TECHNICAL NOTE

Job Name: North Littlehampton

Note No: TN004

Subject: Response to Environment Agency Objection dated 24th January 2022

ELEVATION SINGLE SPAN

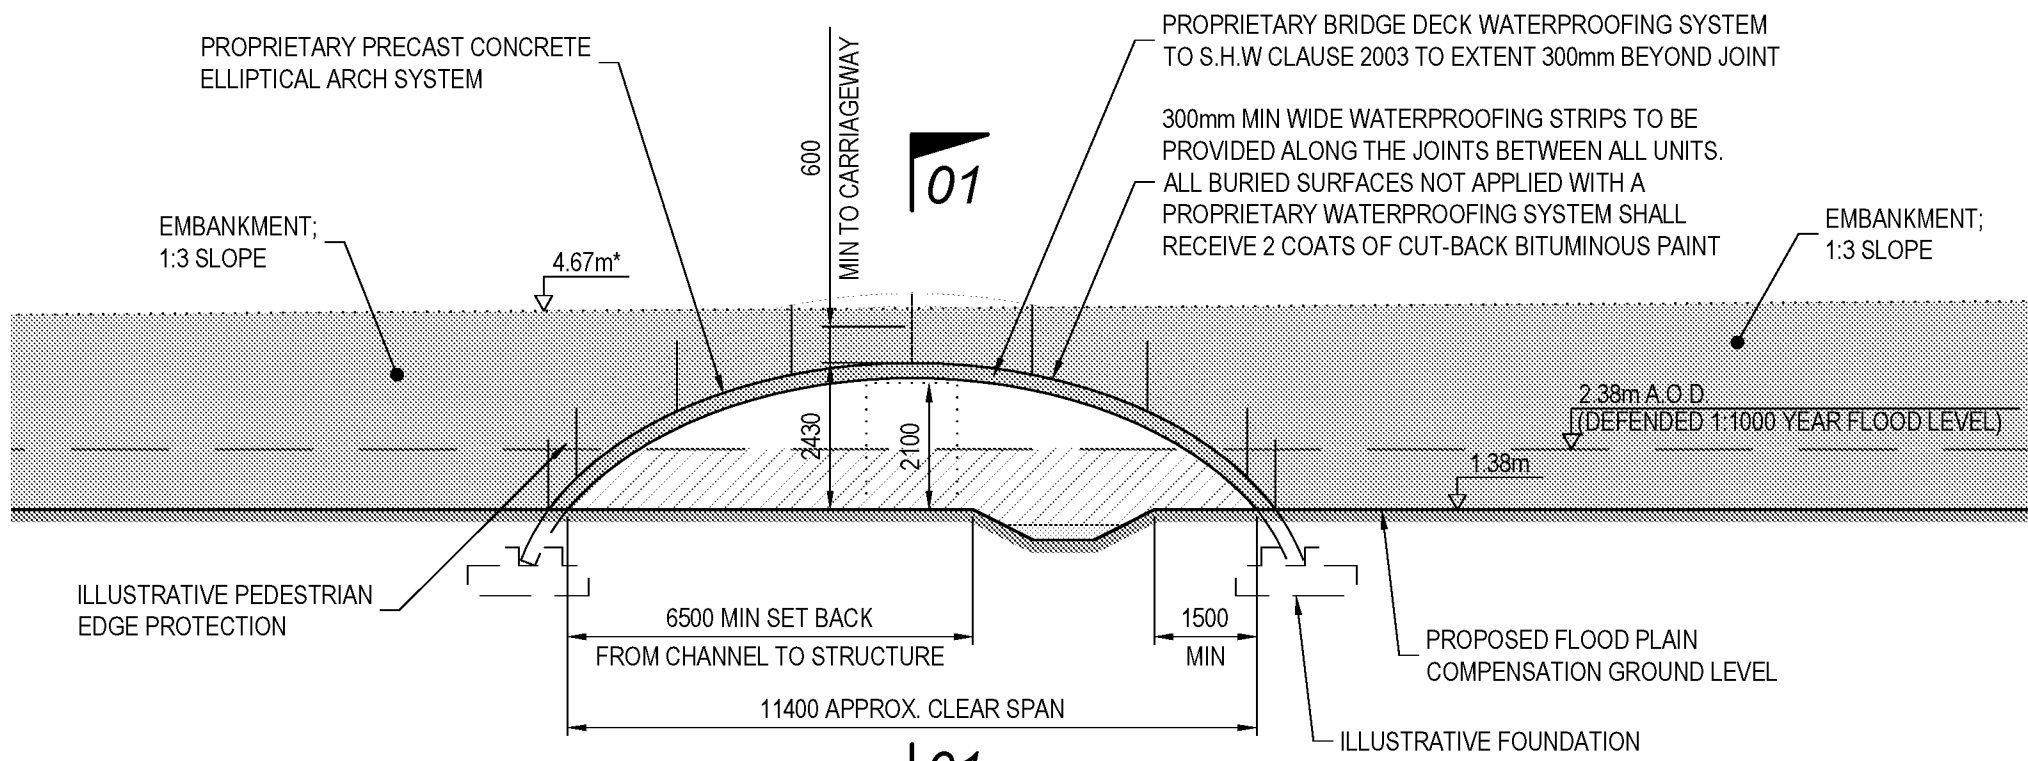
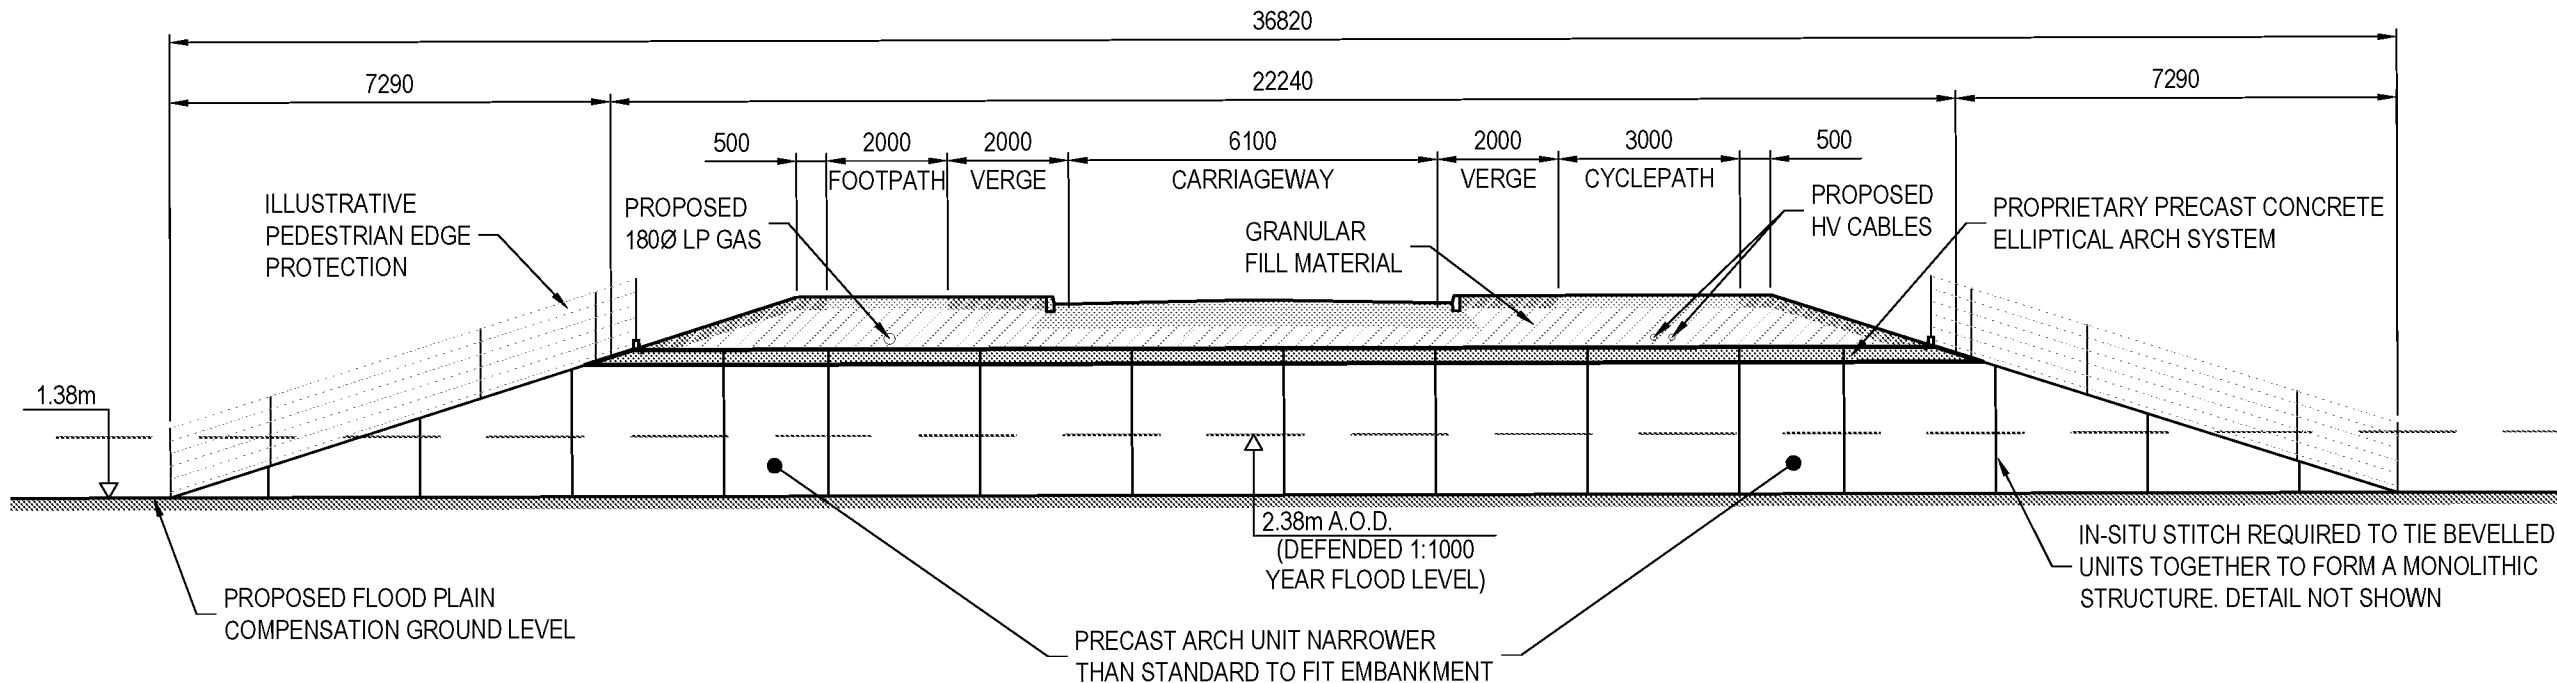
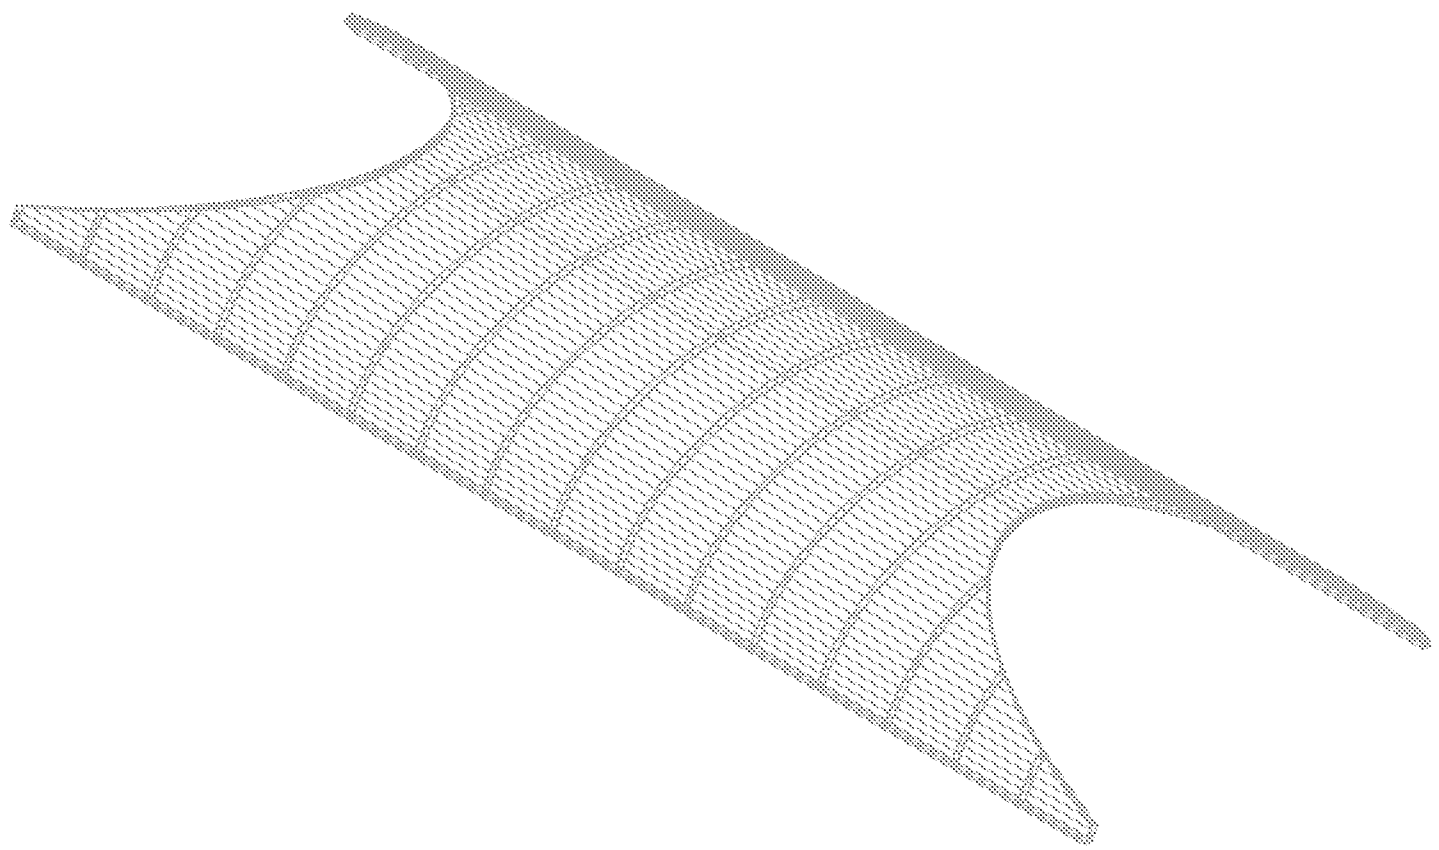
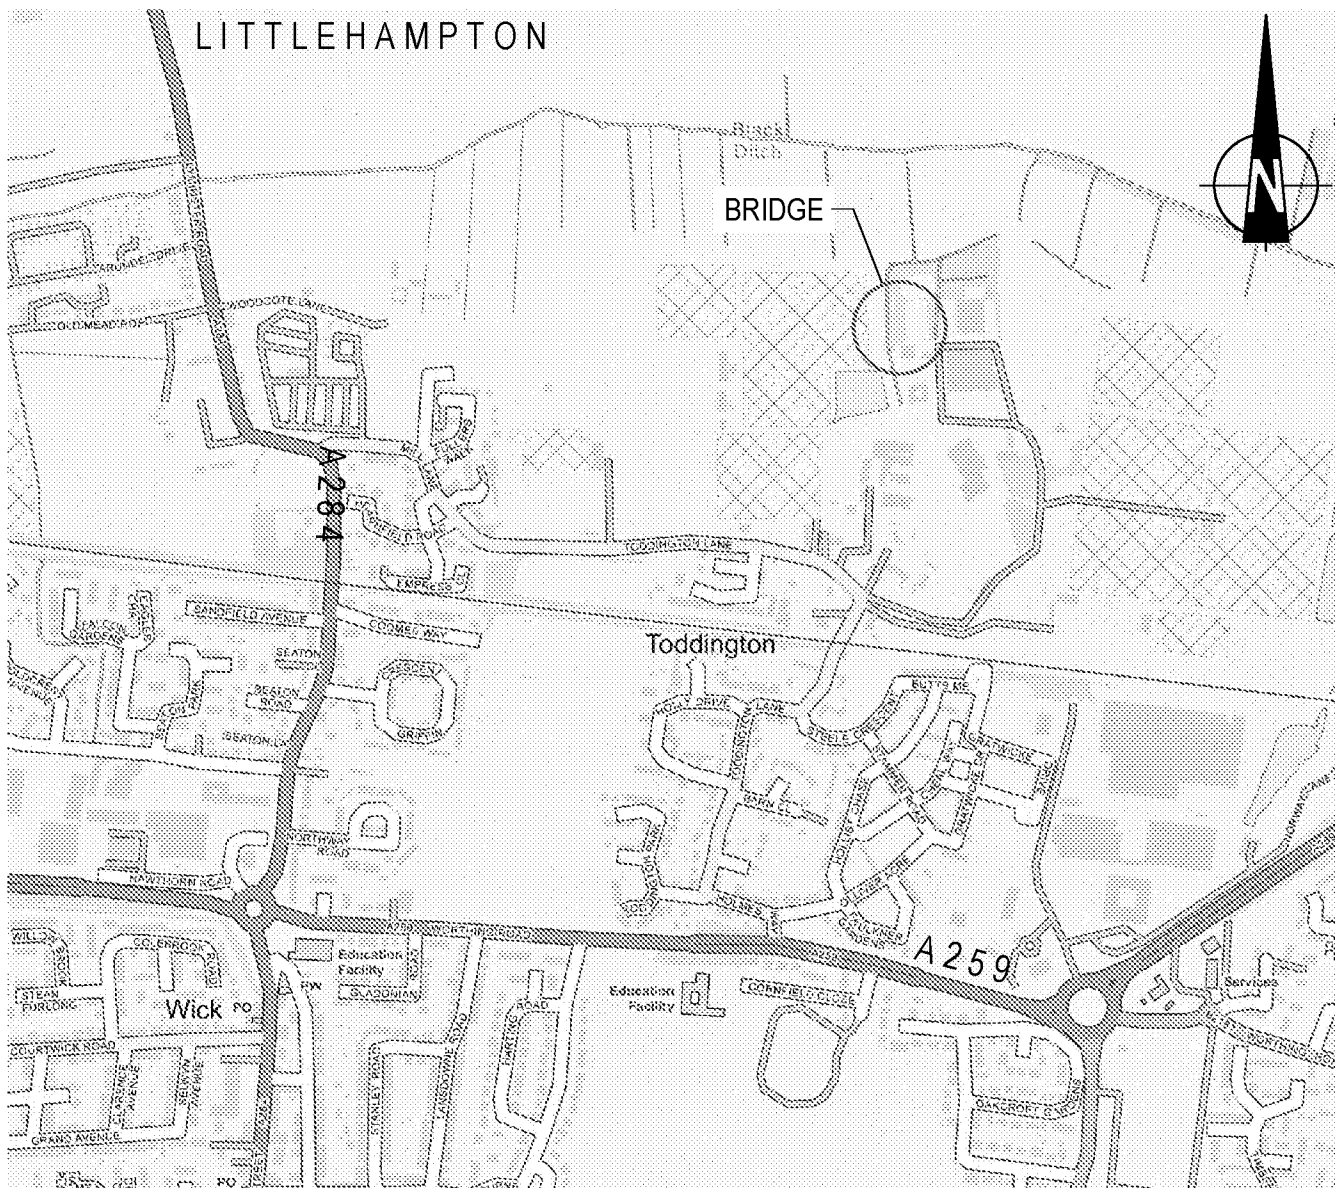
Unsatisfactory information in regard to the watercourse crossings have been submitted.

In our previous responses we stated that the EA will always request road crossings to be of a clear span variety, for the purposes of flood flow. Also, the soffit level should be set at least 600mm above the undefended 1% AEP plus the appropriate allowance for climate change. In this case it appears that defended levels have been considered. Furthermore, culvers have been proposed as a means of crossing for the footpaths which are against EA policy. It'll also be useful if evidence of discussions about the arch crossing can be provided to confirm this was agreed as an appropriate means of crossing.

Within EA permitting for clear span bridges they define a clear span bridge as 'a clear span bridge, being a bridge that requires no bed or bank reinforcement and no support in the watercourse'. We would argue that the precast arch solution proposed meets this description

Drawing 39878_4001_001B provided in Appendix B of TN003 shows the soffit of the road crossing is currently shown 1100mm above the defended 0.1% AEP flood level (2.38m AOD). If the modelled undefended 1% + CC level (2.47m AOD) was used then this reduces to 1010mm.
